Solar park including the erection of solar arrays, inverters, transformers, equipment housing, security fencing, internal tracks, ancillary equipment & ecological mitigation. This application is a Departure from the Development Plan.

Land at Barnham Court Barnham

*For the attention of: Mr Richard Temple
Re: Planning Application BN/29/15PL- OBJECT*

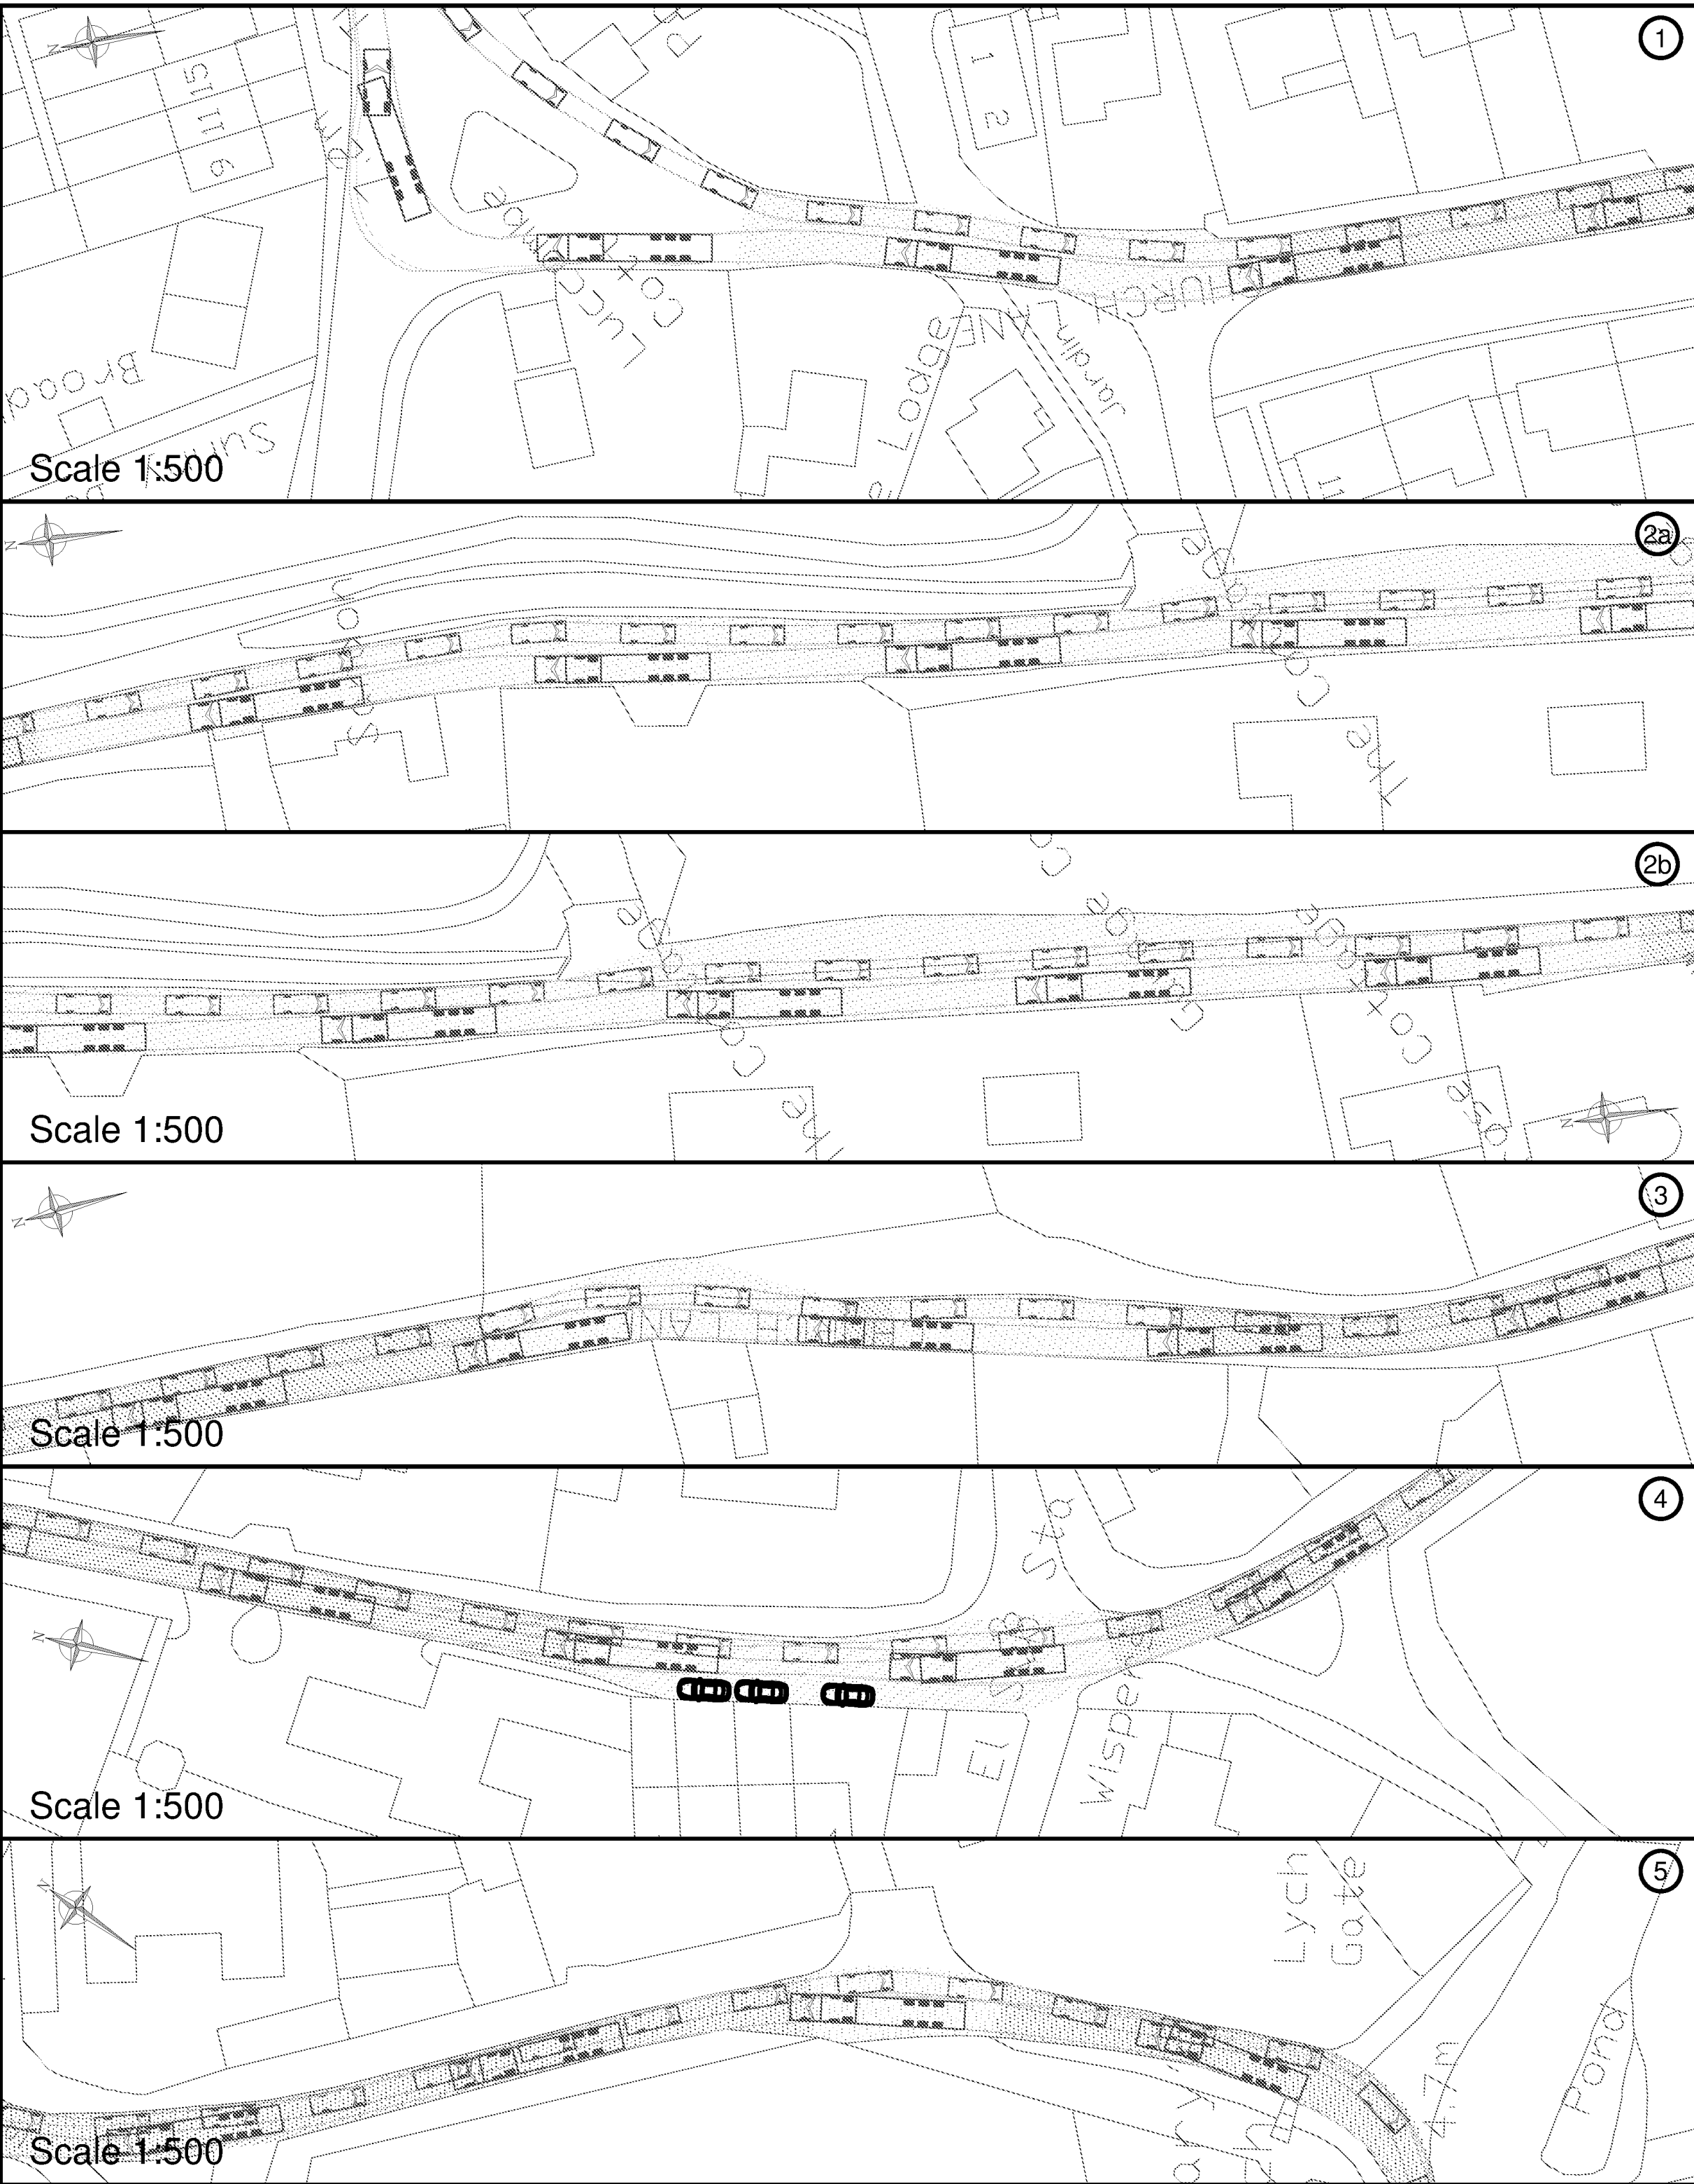
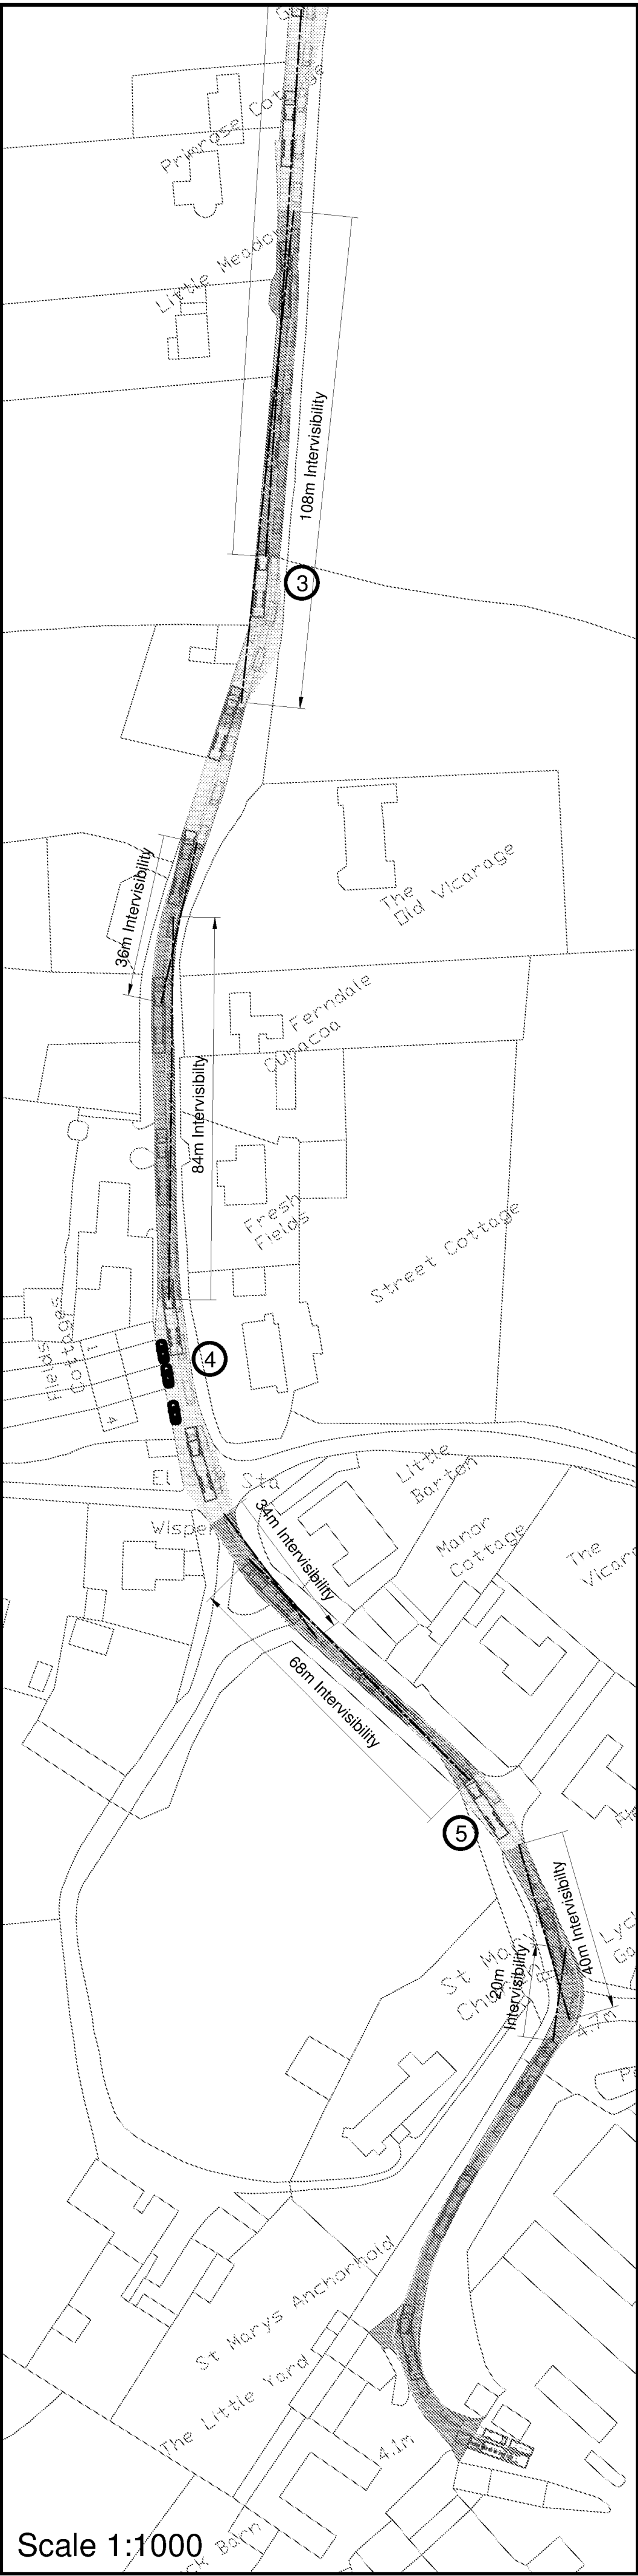
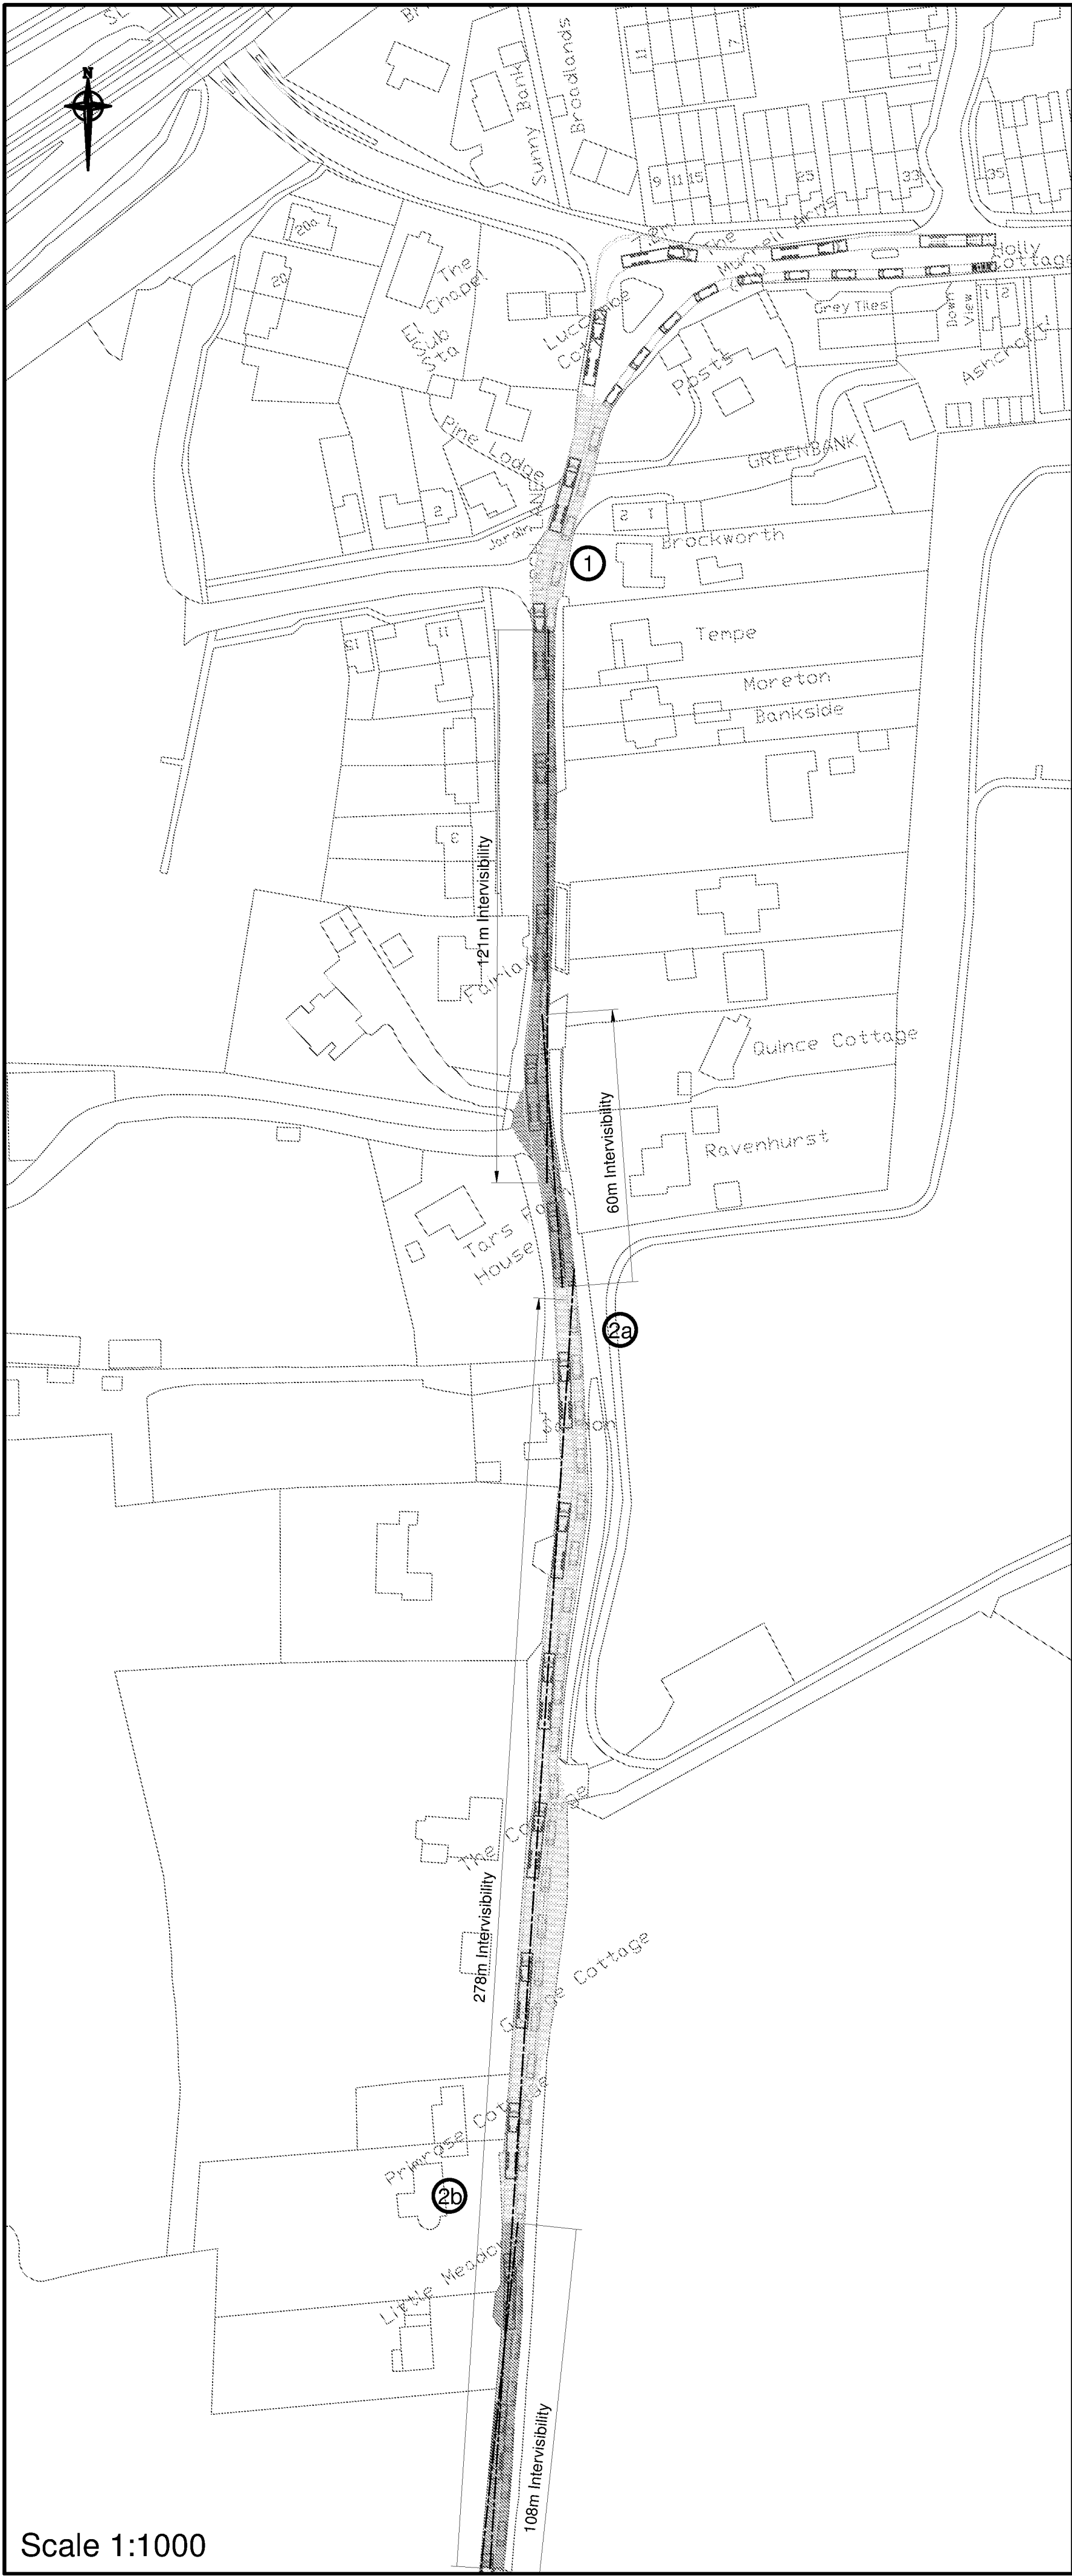
We also note that in their drawing number TPBR 0111 H 002 the shared private drive between Sylvan House and Fieldfares is being proposed as a 'designated' passing place. No permission has been sought for this use and is unlikely to be given. Should Arun DC approve this plan then we would request that a pre and post inspection be undertaken of this private driveway and an order for reparation be required as a condition to the applicant of this planning application.
